PLANNING CONSULTATION RESPONSE

Application No	2026/0266
Proposal	Application to determine if prior approval is required for the change of use of an office building (Use Class E(g)(i)) to 9 apartments (Use Class C3) via Schedule 2, Part 3, Class MA.
Address	23 Queens Road, Barnsley, S71 1AN
Date of Consultation Reply	28 th April 2026
Consultee	Highways DC

**Drawing title:**  
Proposed GF Plan

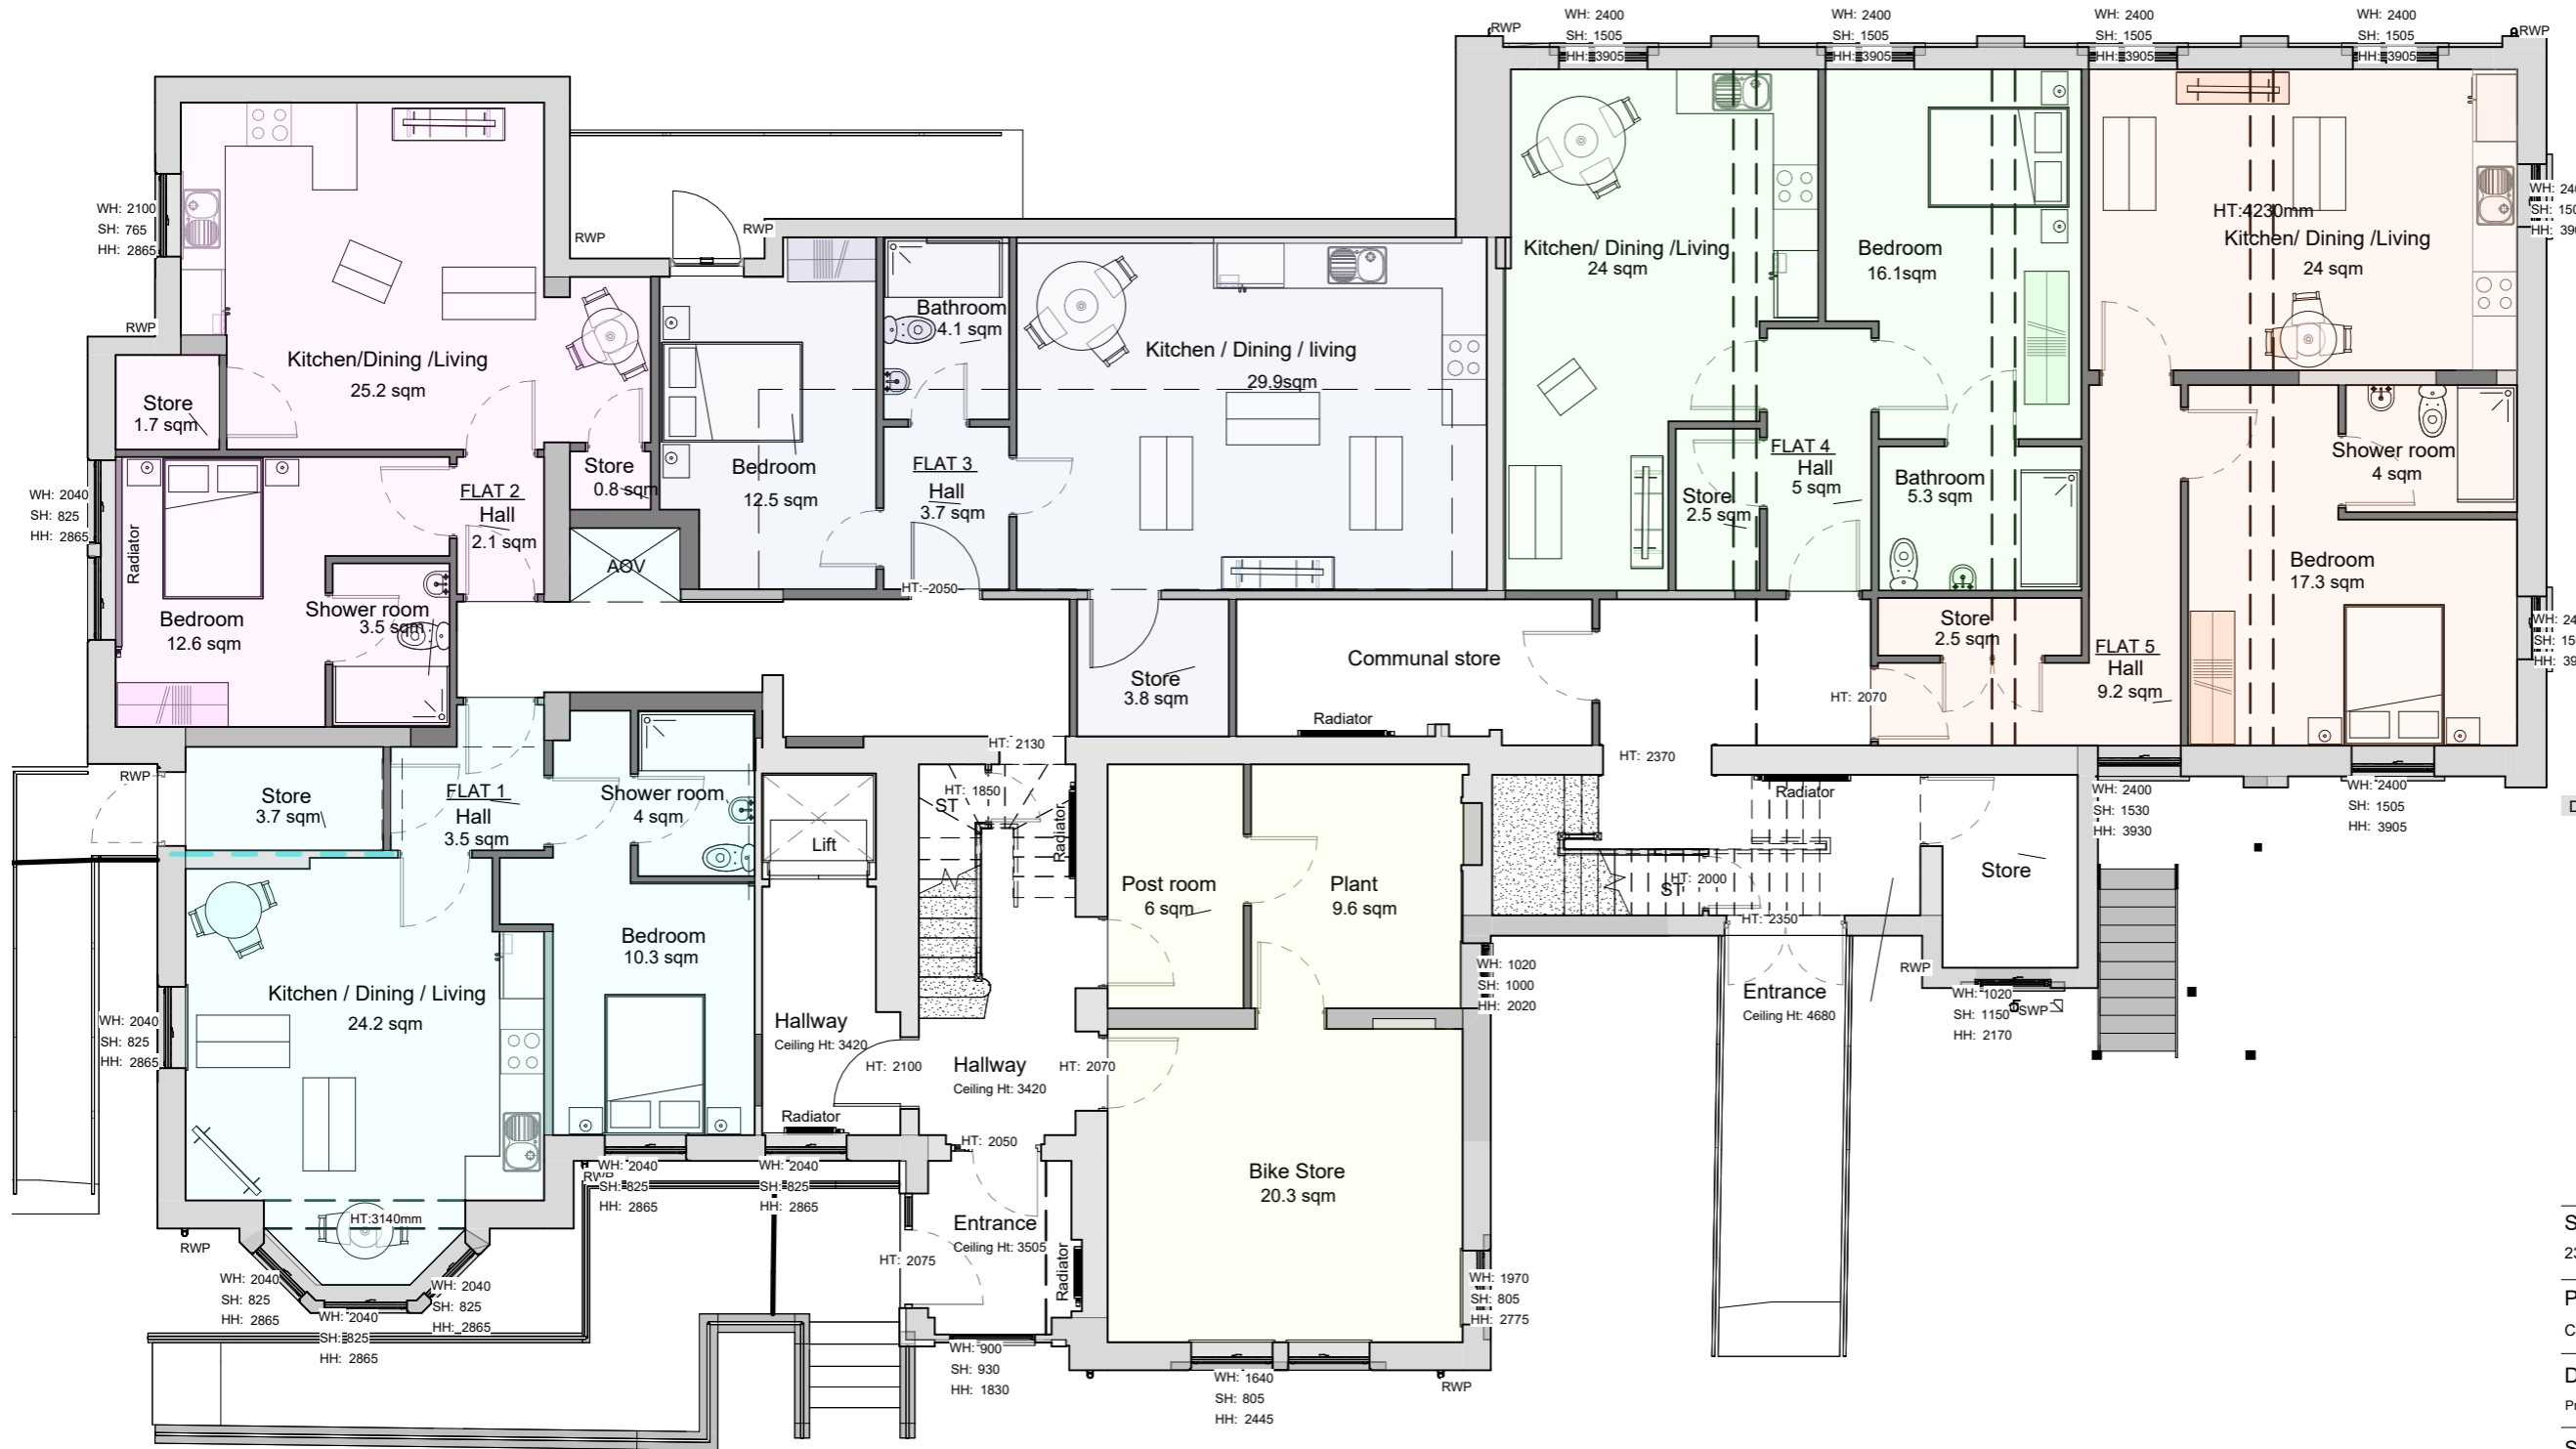
The edge of town centre location means that the site is easily accessible for both pedestrians and cyclists and also benefits from having a large number of amenities within easy reach as well as having good links to public transport facilities with the Interchange being located approx. 320m to the west. The proposed ground floor layout plan shows that a cycle store is to be provided within the building and is of sufficient size to accommodate at least one bicycle per apartment.

Prior to the development being brought into use, the scheme for the storage of bicycles as shown on the submitted plans shall be fully implemented and thereafter retained for this purpose.
